Subject: Application ID: 2013-255

Comments Submitted by: Ann Machado/Zoning on 12/9/2013

118 Congress Street is located in the B-1 Neighborhood Business Zone . The project calls for two retail units and twelve dwelling units. The first floor will have the two retail spaces along Congress Street with 18 parking spaces in the rear of the building accessed off of St Lawrence Street. The proposed use requires 12 parking spaces which is being met. The existing building on the lot will be demolished. The lot is 10,728 square feet. The minimum street requirement of 50' is being met. The front of the property faces Congress Street. The front and side setbacks for the first floor are being met. Above the ground floor on the second through fourth floors on the west and north sides of the building the enclosed (frosted glass) living areas and decks appear to encroach 2.5' over the side and front property lines. Part of the rear yard of the property abuts a property (25 Monument Street) with a first floor residential use which requires a 20' setback for that part of the lot. This is not being met at the present. The building is 5'3" from the rear and the three decks scale at two feet from th

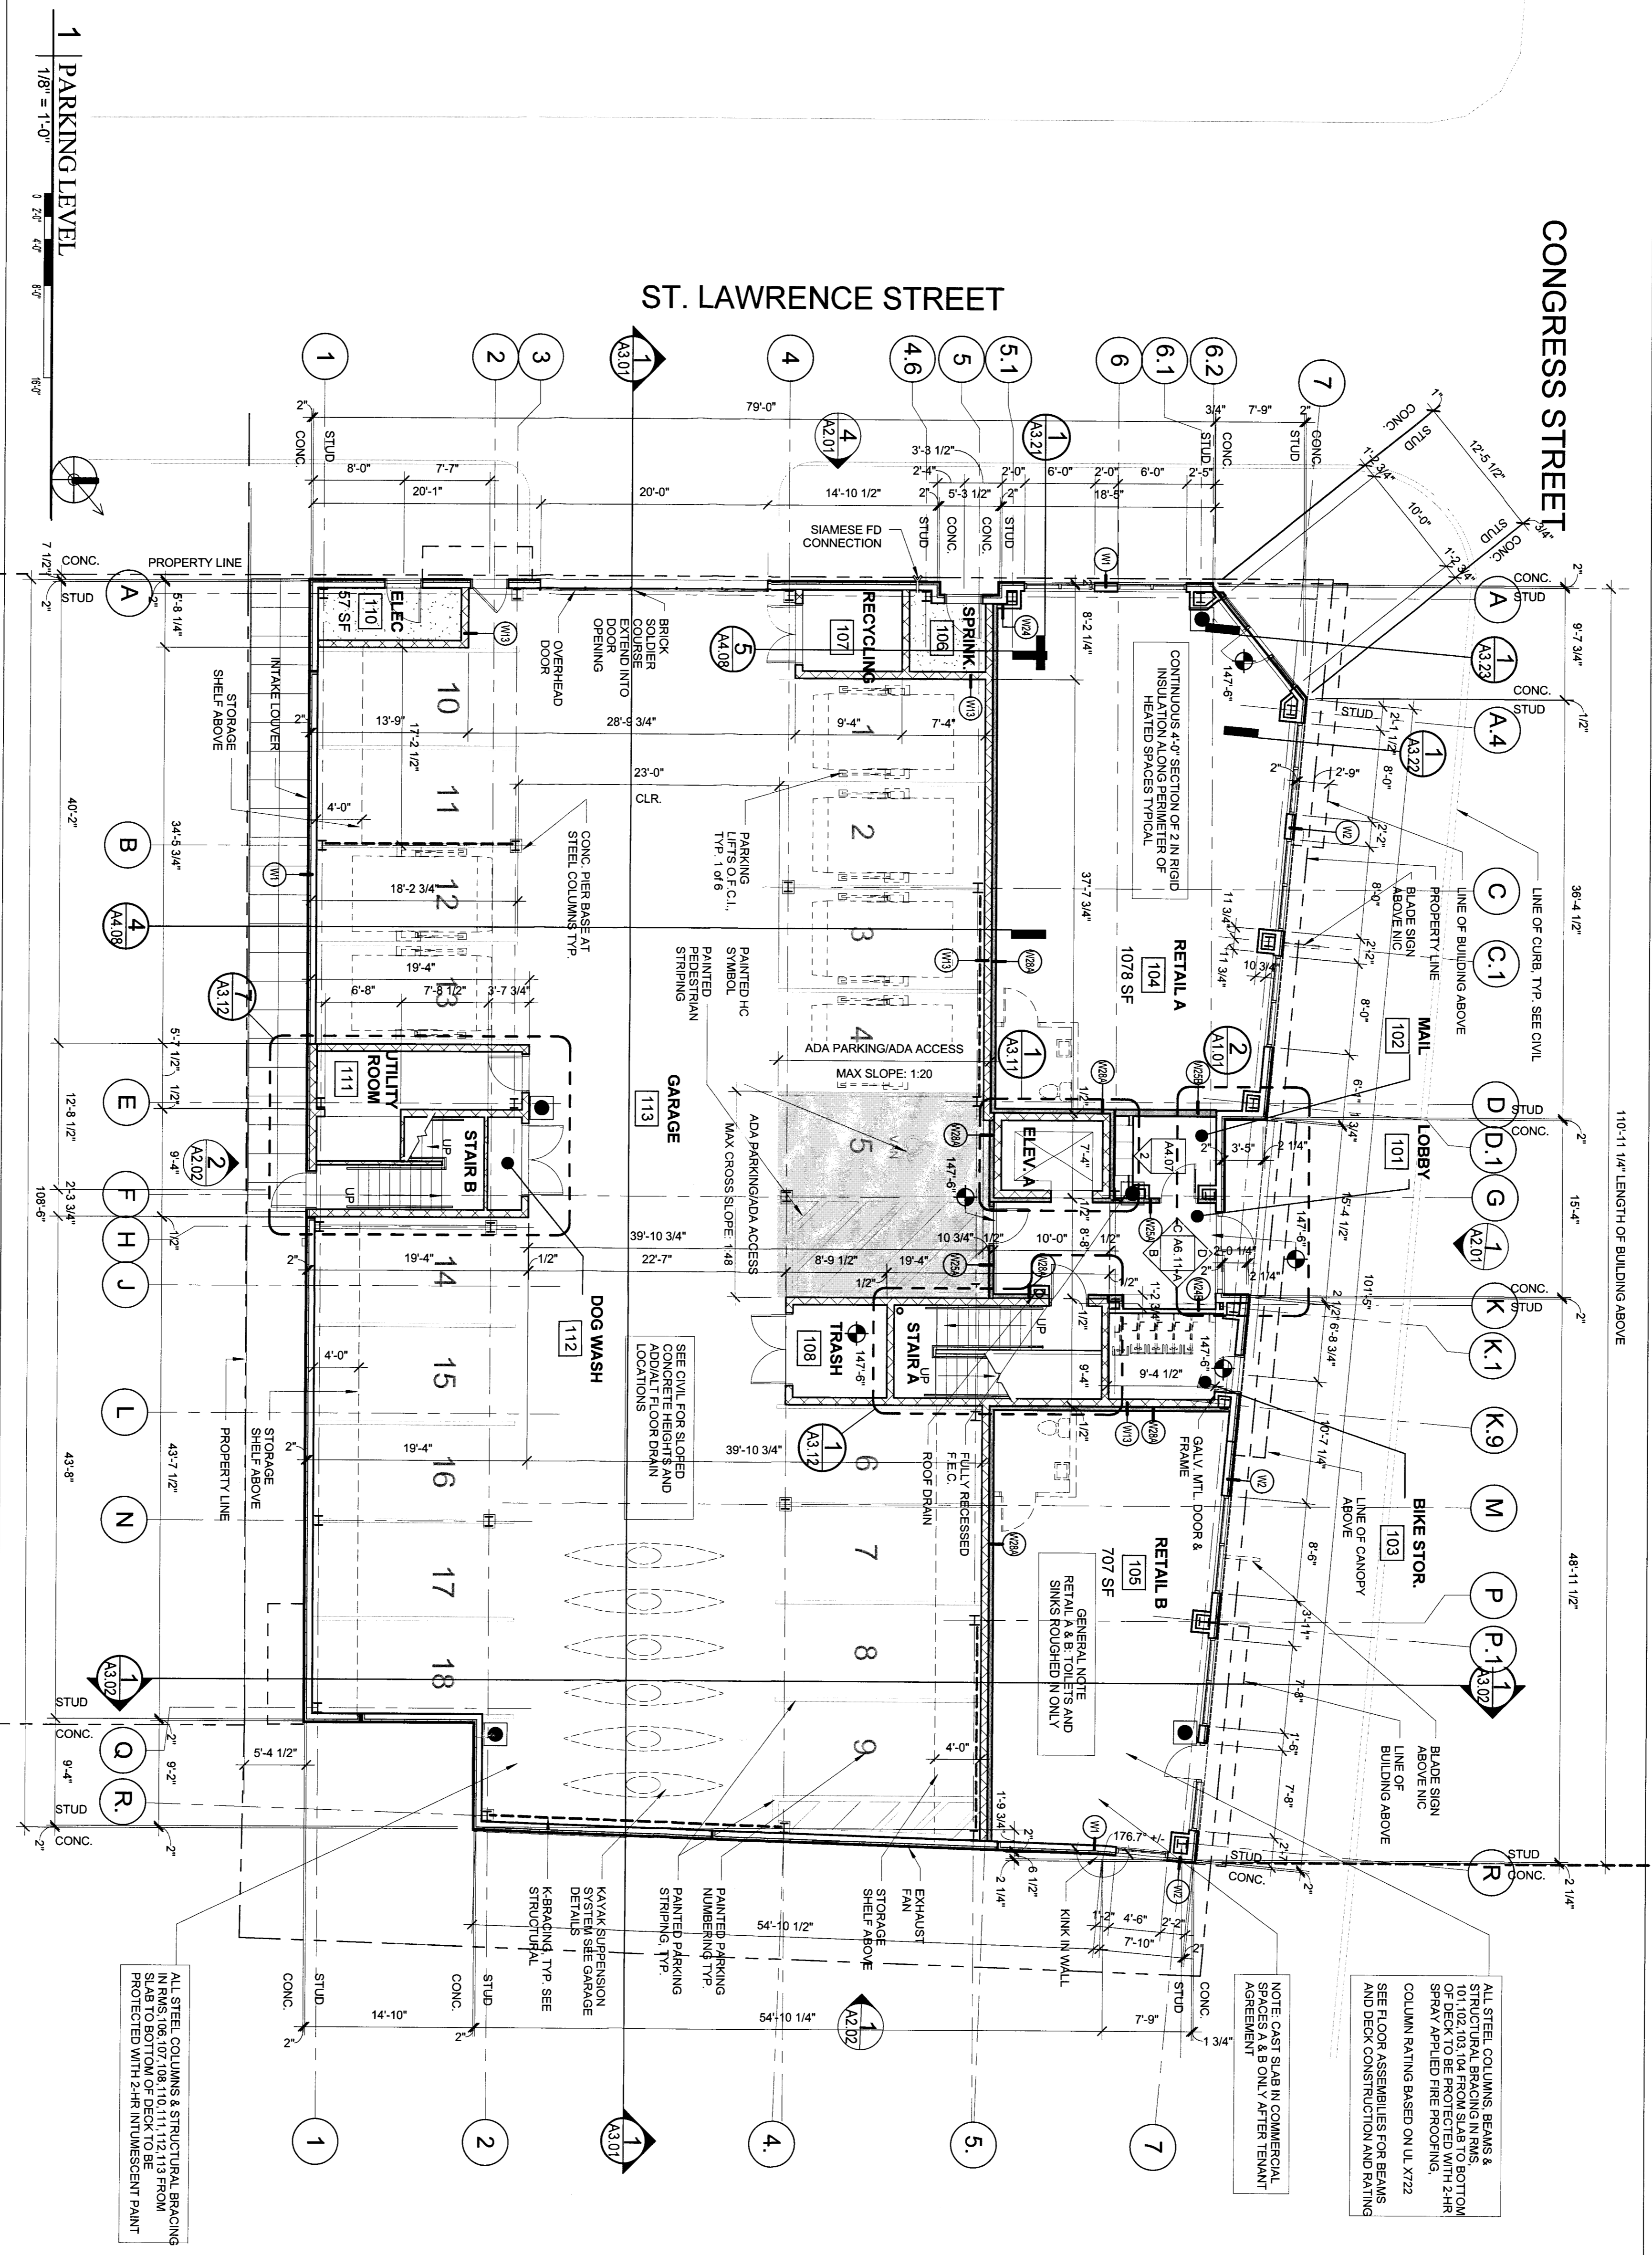
Looked at revised plans submitted 12-6-13. A1.1 shows that the proposed building now meets the 20' rear setback behind 25 Monument Street. The overall footprint of the structure has been reduced to 8,981 sf. Parking spaces 15-18 have been reduced to 8.5" by 18'. A1.02 shows that the length of the deck & enclosed glass bumpout has been reduced to 19.5'. on the western elevation towards the rear of the building. The enclosed (glass) living areas and the decks on floors two through four still encroach 2.5' over the property line on the west and north sides of the building and still extend 3' off the principal structure.. The two blade signs shown on A1.01 are not being approved at this time.
